Current Zoning: N1-C (neighborhood 1-C) and N2-B (neighborhood 2-B)
Proposed Zoning: UR-2(CD) (urban residential, conditional)

Approximately one acre located on the south side of Parkwood Avenue, east of Hawthorne Lane, north of Belvedere Avenue, and west of The Plaza.

The petition proposes to rezone a vacant parcel in the Plaza Midwood neighborhood to allow 18 single family attached residential units.

Staff recommends approval of this petition upon resolution of outstanding issues related to transportation and site and building design.

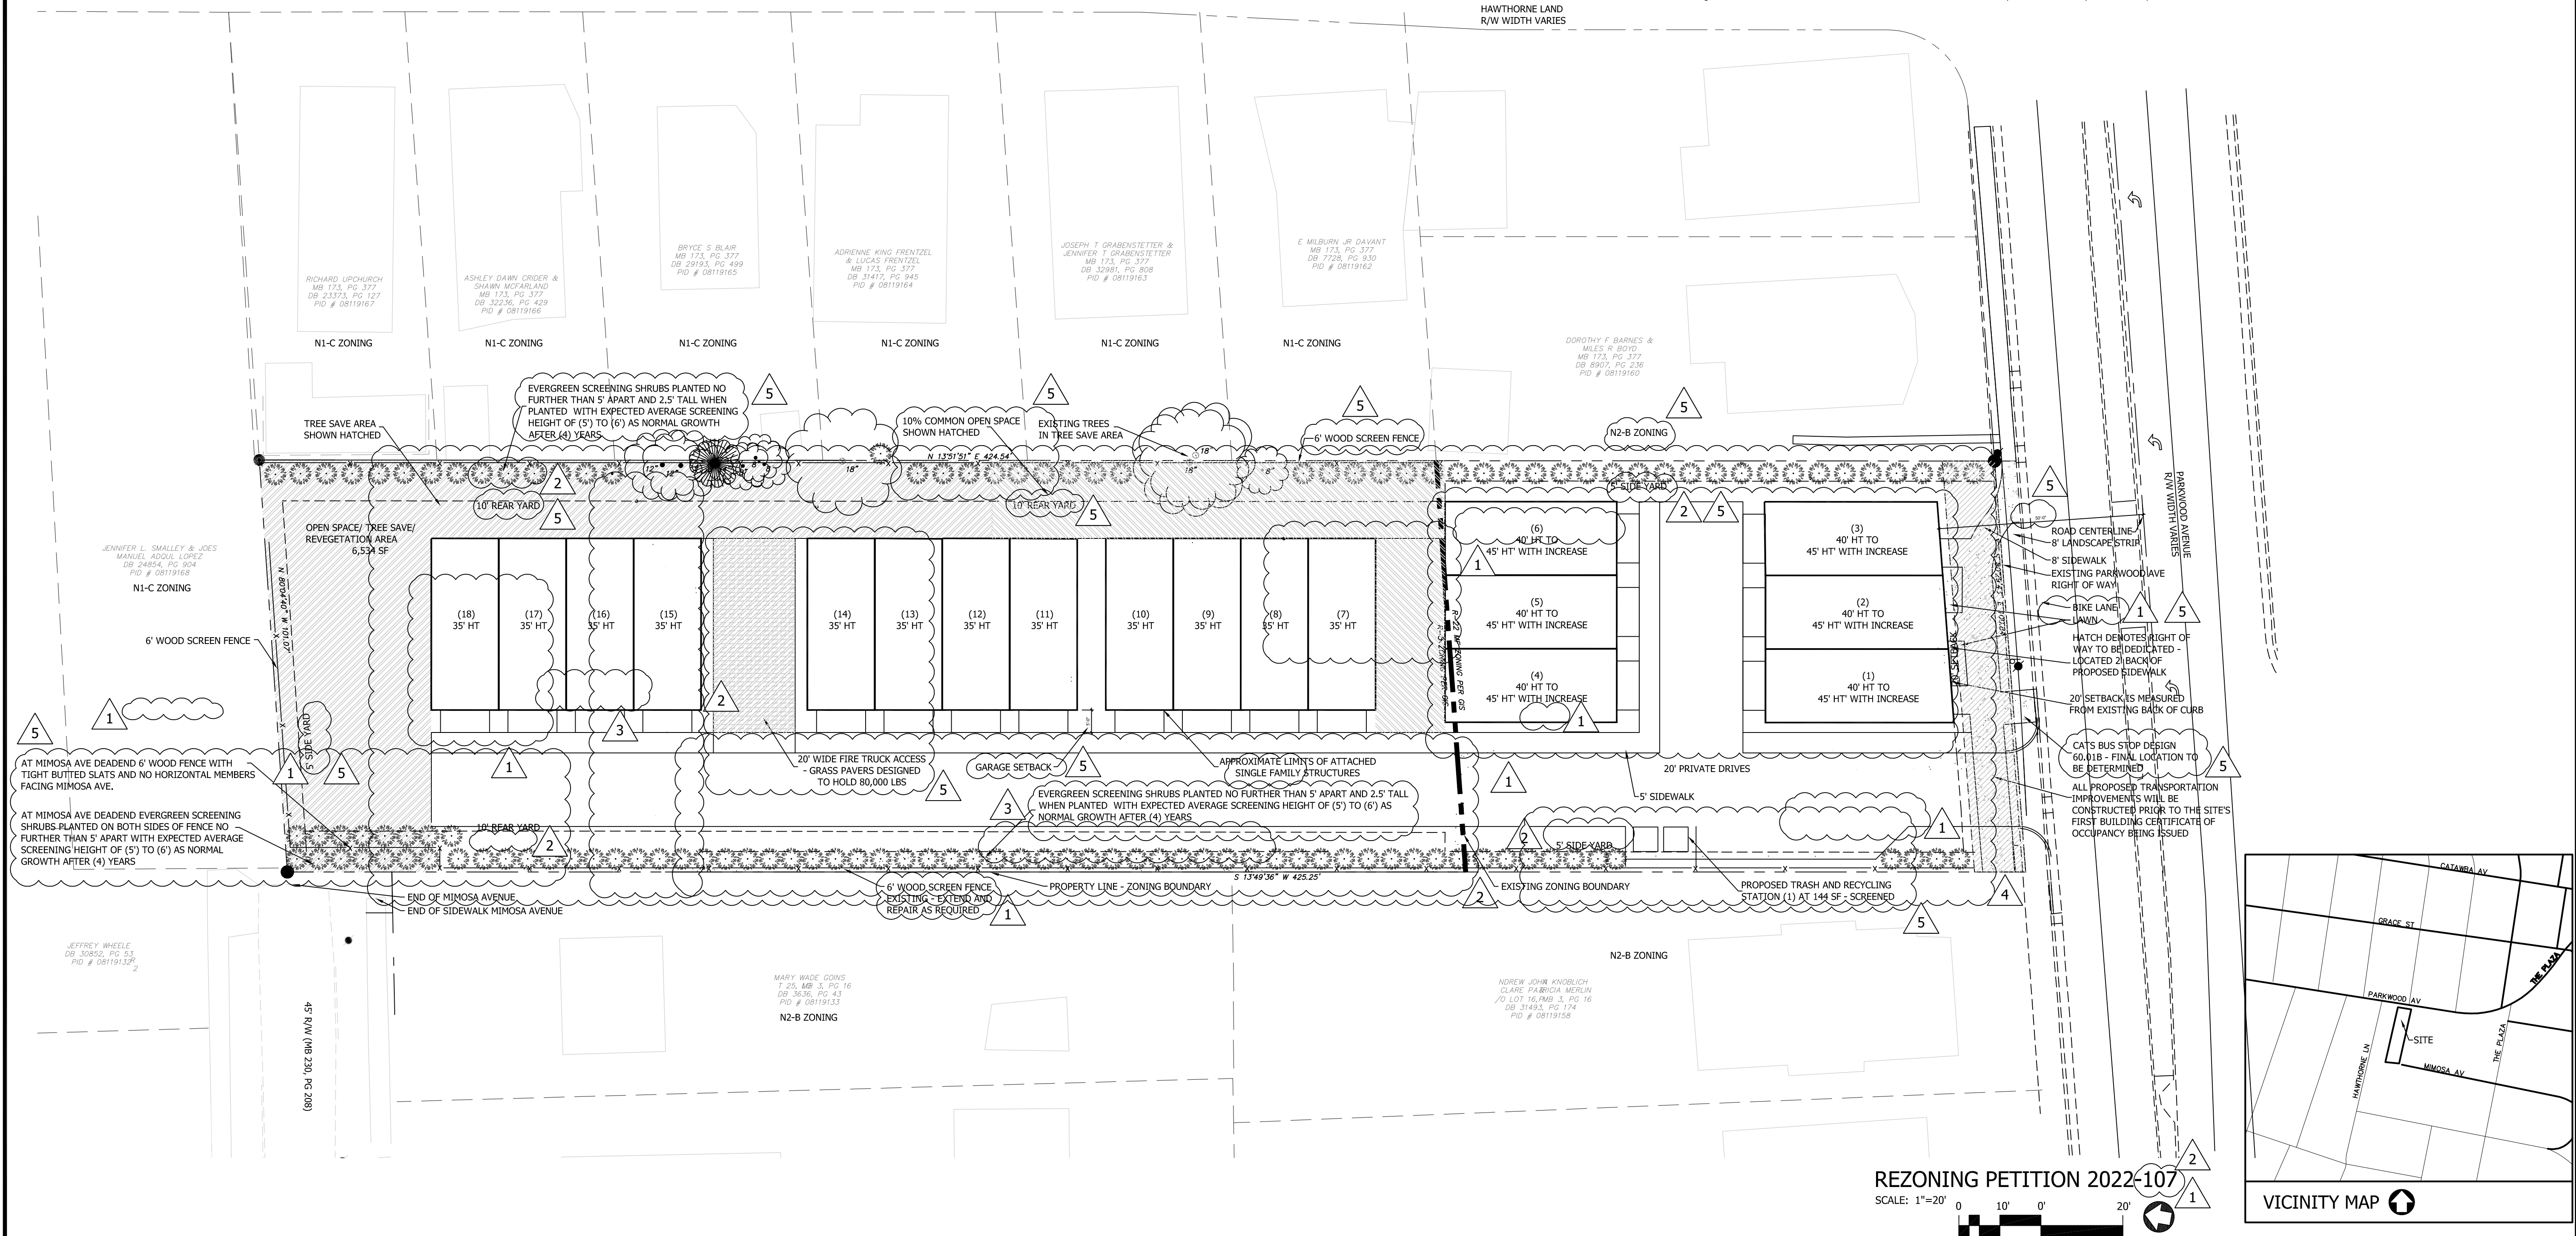
1. Label and dimension the existing and future curb and gutter from the centerline for each road on the site plan. Streetscape elements should be constructed at the back of future curb and gutter.
2. Revise site plan and conditional note(s) to commit to dedicate 56 feet of right-of-way from the road centerline. The site plan shall label and dimension the right-of-way from the road centerline.
3. Site plan only shows hatched area, petitioner should label and dimension the right-of-way from the centerline for each road on the site plan.
4. The site is located on CATS local bus route #4 along Parkwood Avenue. CATS requests the construction of ADA compliant bus stop type 60.01B. The final location will be determined during the Land Development plan review process. This shall be an upgrade to the existing bus stop at this site.

5. Revise language to state parking will be provided per ordinance.
6. Please clarify what is meant by "lawn" in the setback, as this needs to be clarified on the plan

7. Please provide the width and location of the landscape screen clearly. Please ensure it noted and all the required plantings in landscape screen areas clearly defined. Add a development note committing to the landscape screen details along the east and west property lines.
 8. Some of the notes under Architectural and Design Standards are repetitive, and some seem to reference a single building while others reference single family attached. Please revise accordingly.
 9. Please show staging area/how the dumpsters and recycle carts will be serviced on the site.
-
